**RE: 3404 Stanford Dr. NE Addition
Grading and Drainage Plan
Engineer's Stamp Date 9-14-2016 (File: G16D151)**

From: Carrillo, Abiel X.
Sent: Friday, August 05, 2016 3:39 PM
To: 'asheng505@hotmail.com'
Cc: 'aecllc@aol.com'; Michel, Racquel M.
Subject: 3404 Stanford - G16D151

Re: 3404 Stanford Dr NE Addition
3404 Stanford Dr NE
Traffic Circulation Layout
Engineer's Stamp 07-28-16 (G16D151)

3404 STANFORD DR NE ADDITION
GRADING AND DRAINAGE PLAN

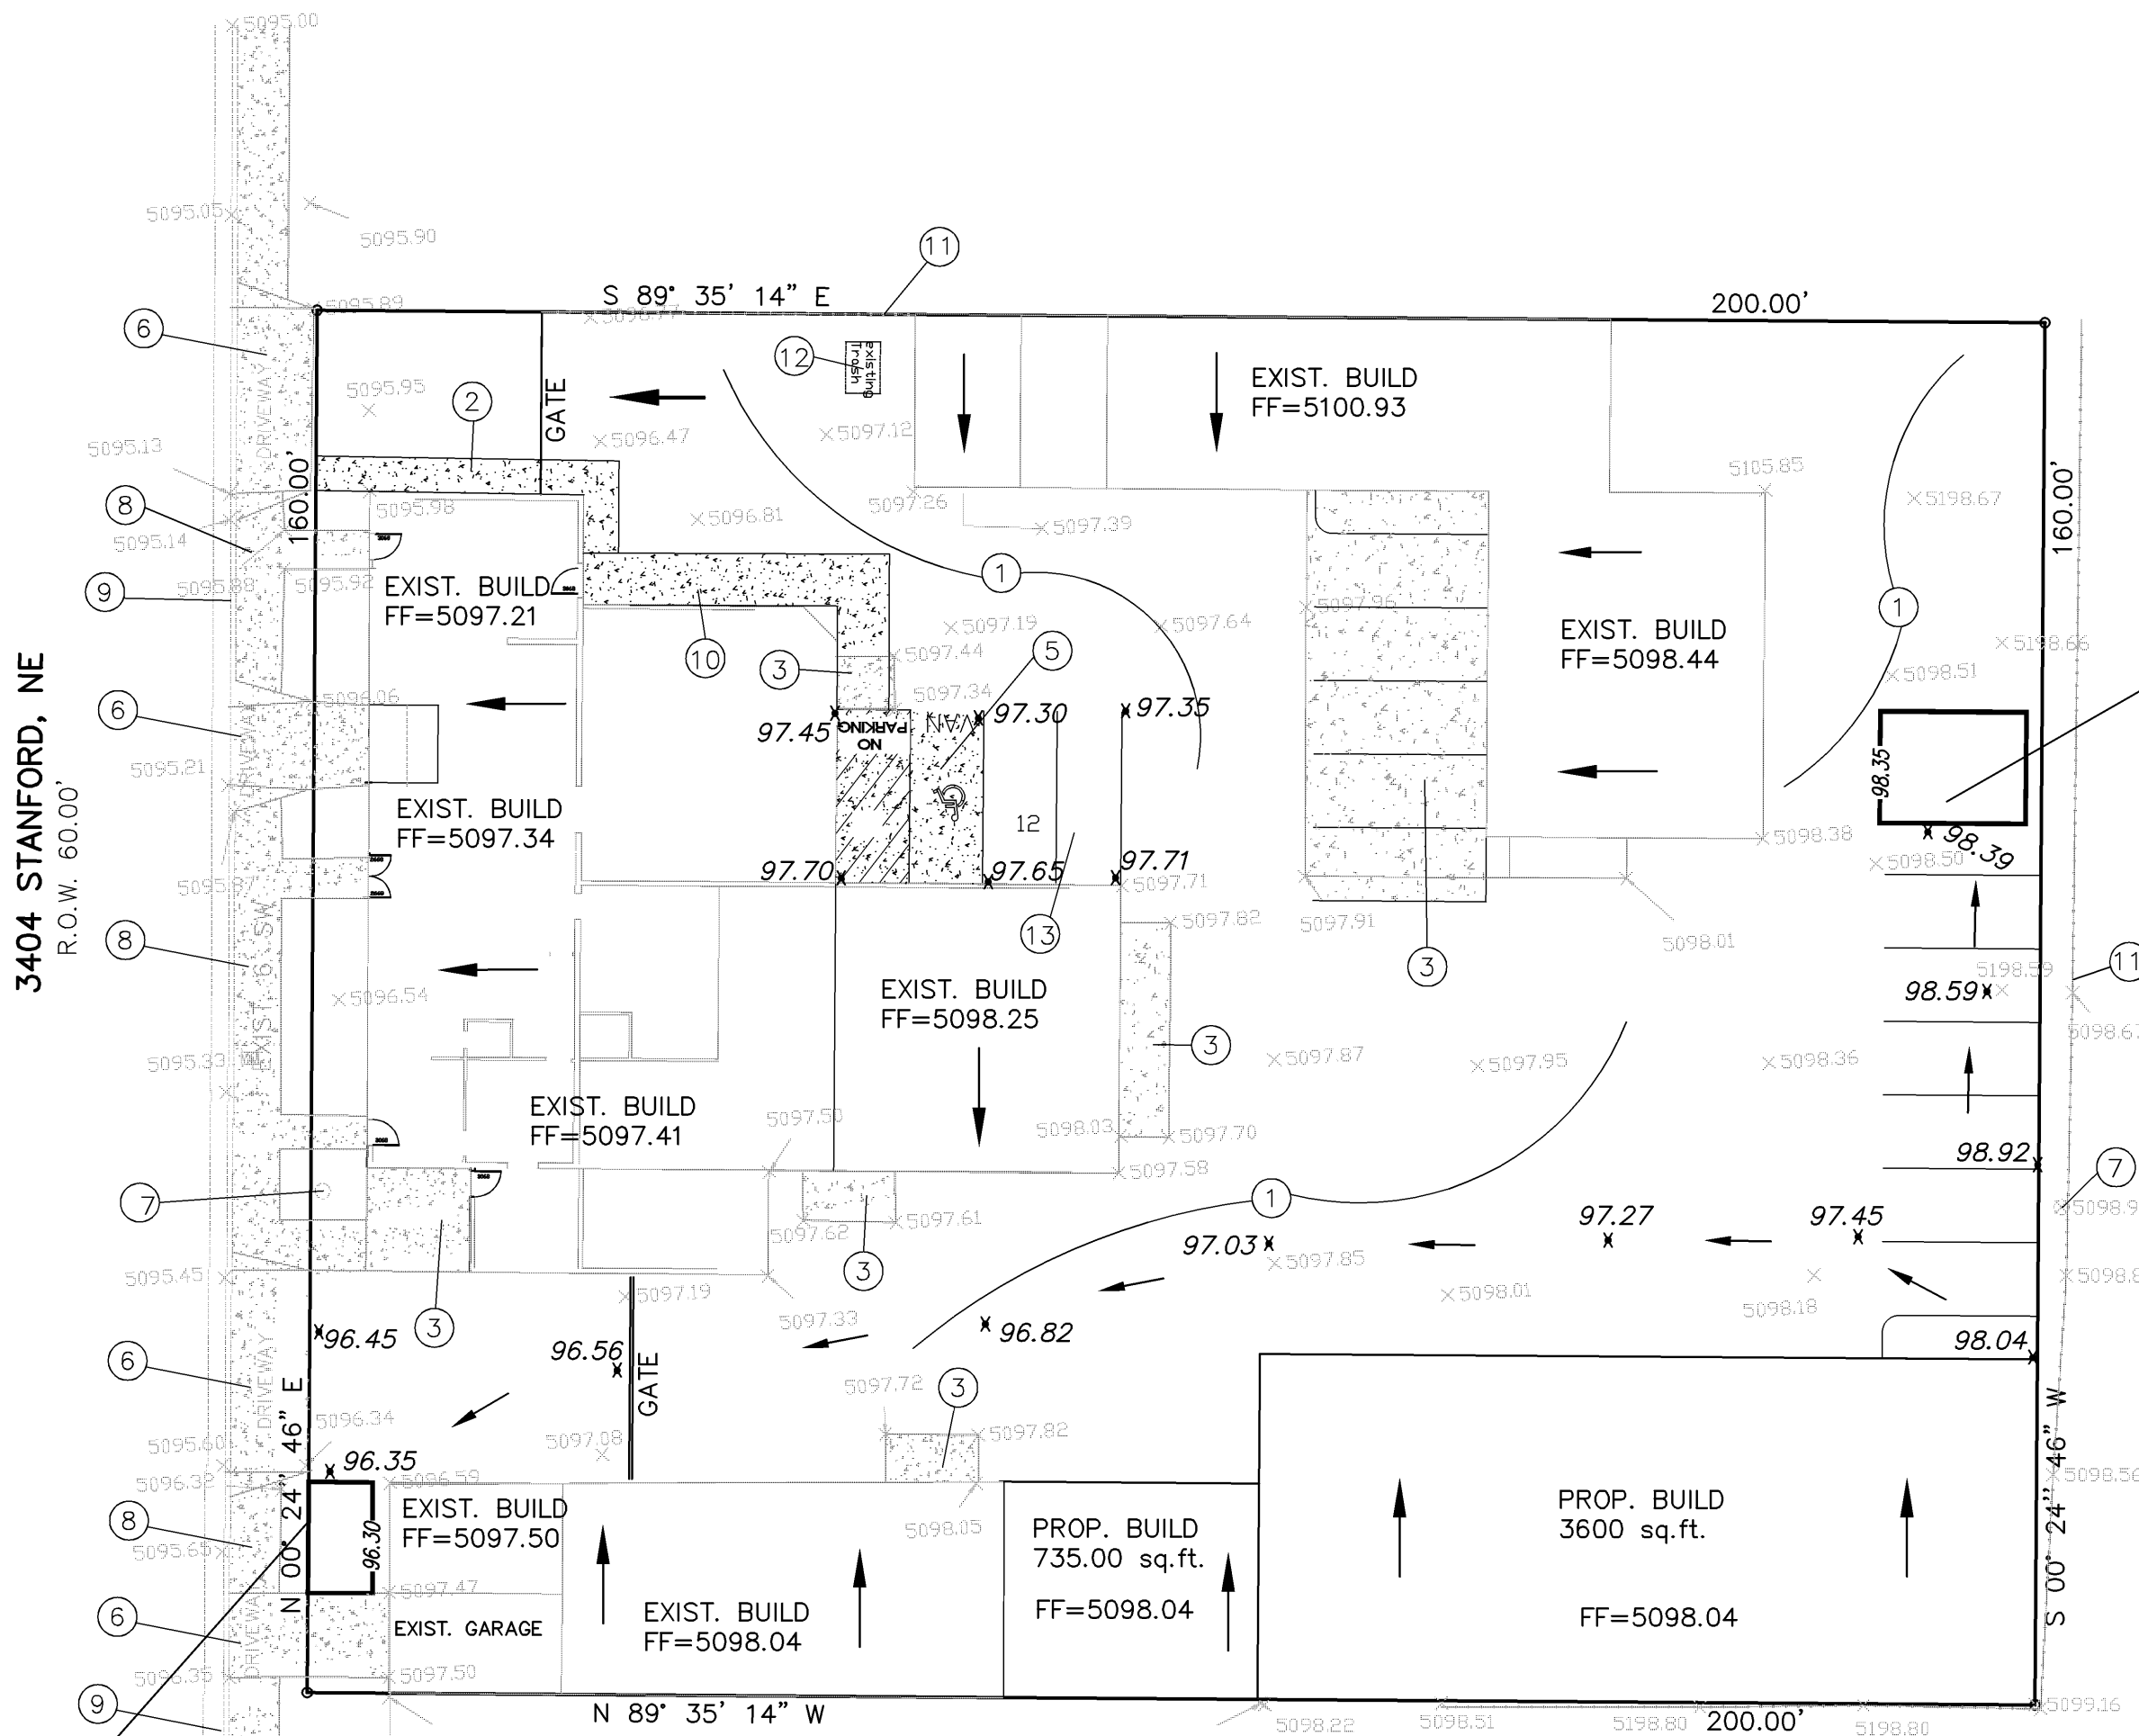
1. It is not clear what the limits of the improvements are, provide hatching for new asphalt and paved surfaces within the site.
Not completely clear, but negligible impact to Hyd.

- a. Clarify what the existing parking lot/access surface is (gravel, paving). It is not clear from aerial photos.
2. Provide elevations and build notes for new paving and concrete. There appears to be a new concrete parking area proposed.

3. Clarify the extent of the improvements within the Right of Way. The sidewalk and driveways are hatched as if they are existing, but it appears that some are actually proposed. The plan should include build notes and elevation data for the contractor to follow, particularly since part of the sidewalk is replacing a sloped, paved, continuous driveway.
Existing

- a. New sidewalk in the right of way will need to reference the City's revised 2405A and B Standard Drawings.
4. Provide top and bottom elevations of the first flush ponds, and a conceptual cross section. The line work suggests a drop off at the edge of the ponds.
They're just going to be depressions in the parking lot

5. It is not clear that any flow would reach the westernmost first flush pond.
- ✓ 6. Show the direction of the roof drainage, to ensure that it is planned to discharge within the property.

3404 STANFORD DR NE ADDITION  
TRAFFIC CIRCULATION LAYOUT

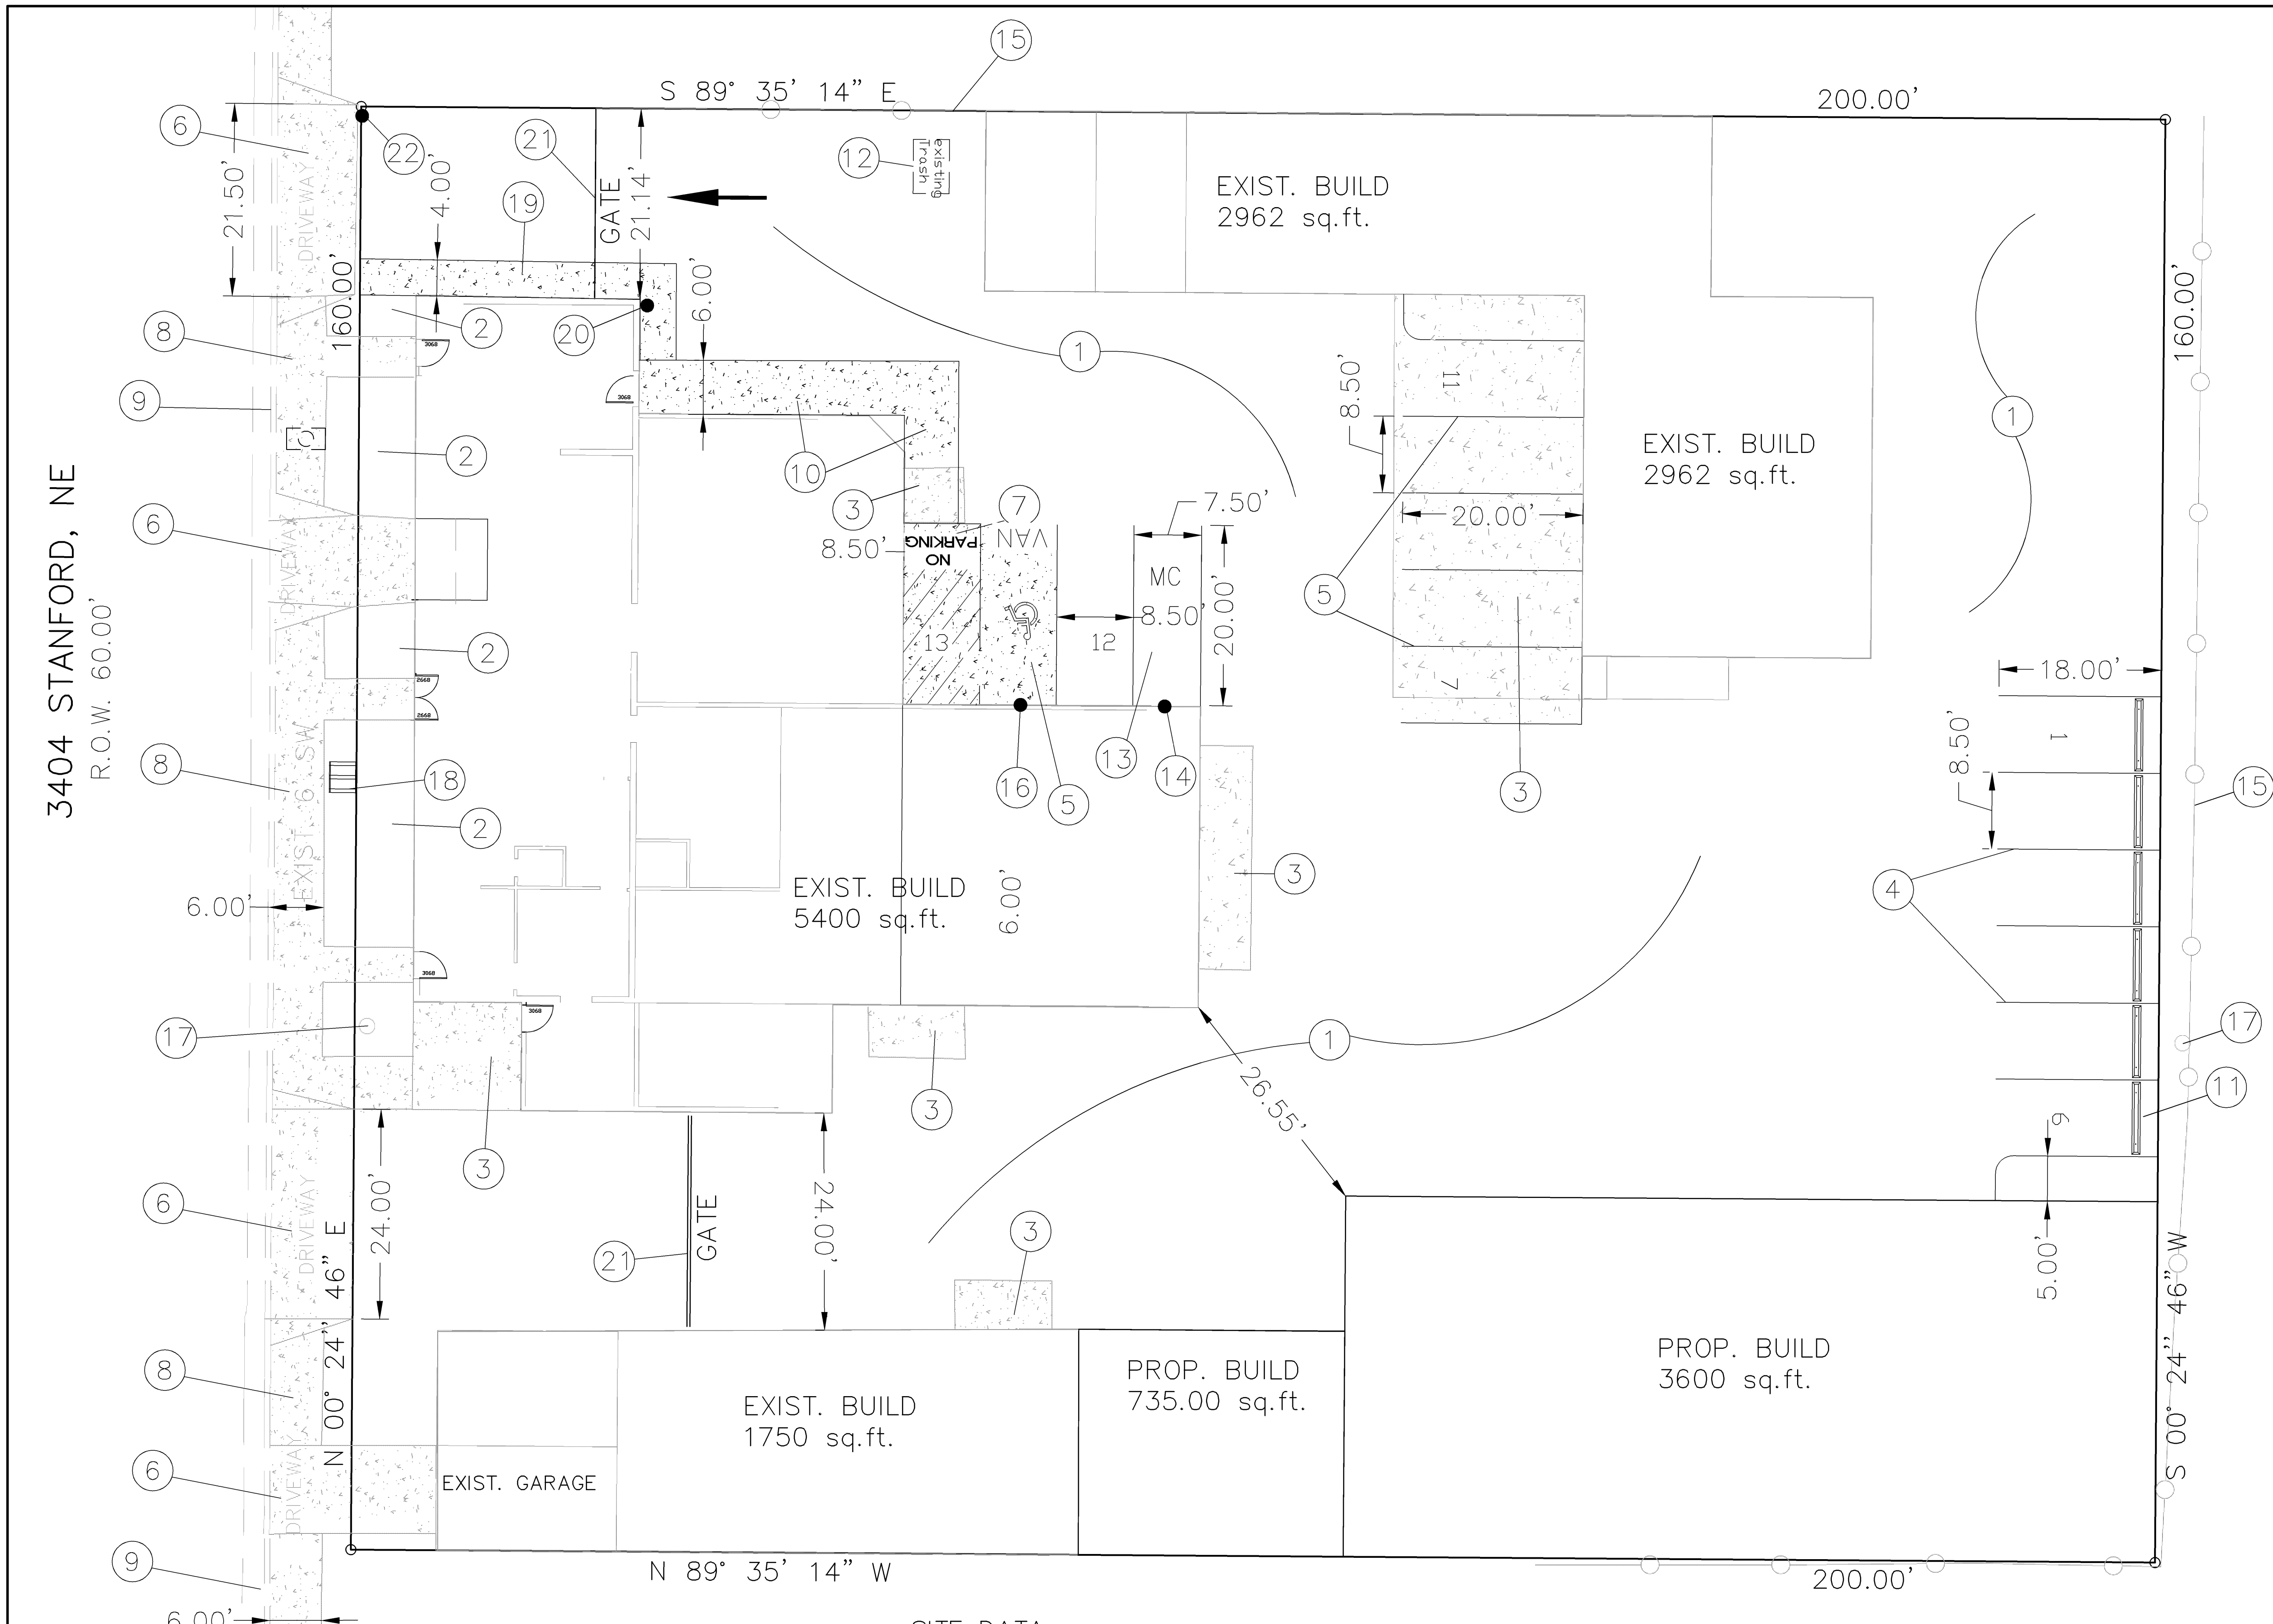
1. Show all drive aisle widths and radii. *Call out one way*
2. List radii for all curves shown; for passenger vehicles, the minimum end island radius is 15 ft. Landscape island radius for delivery trucks, fire trucks, etc. is 25 ft. or larger.

3. Per DPM, a 6 ft. wide ADA accessible pedestrian pathway is required from the public sidewalk and handicapped parking to the building entrances. Please clearly show this pathway and provide details.

4. Per DPM, a 6 ft. wide ADA accessible pedestrian pathway is required from the HC parking stall access aisles to the building entrances. Please clearly show this pathway and provide details.

5. All sidewalks along streets should be placed at the property line.
6. Service vehicle and/or refuse vehicle maneuvering must be contained on-site; provide a copy of refuse approval.

7. Please specify the City Standard Drawing Number when applicable to all curb cuts and ramps.
8. Work within the public right of way requires a work order with DRC approved plans. Please add a note on the plan stating "All improvements located in the Right of Way must be included on the work order."

9. See Chapter 23, Section 6 of the City of Albuquerque *Development Process Manual*, for appropriate drive pad widths.
10. All broken or cracked sidewalk must be replaced with sidewalk and curb & gutter. A build note must be provided referring to the appropriate City Standard drawing.

- 1) The drive aisle are existing and dimensions are shown on the plan. I did show you the pictures of the driveways in the meeting that we had.
- 2) The drive aisle are existing. The were built per City Std. DWG 2425. There are no radiuses.

- 3) There are existing pedestrian walkways along Stanford. Per your request at the meeting we had, to show a 4' wide pedestrian walkway at the north connecting front sidewalk to the back of the building, see note 19 on key notes.

- 4) We have modified this pathway to 6' wide, see key note 10. We have also relocated the handicap parking to the west as per instruction in the meeting.

- 5) The existing 6' sidewalk follows the existing sidewalk along Stanford and do not need to be relocated.
- 6) The location of existing trash enclosure is shown on the plans and as per our meeting you said we do not need to get refuse approval.

- 7) All the sidewalks and driveways are existing and there no proposed construction for this project.
- 8) There are no construction proposed.
- 9) We have look at the DPM. We are not proposing any new construction.

- 10) We are not proposing any new construction for this site.
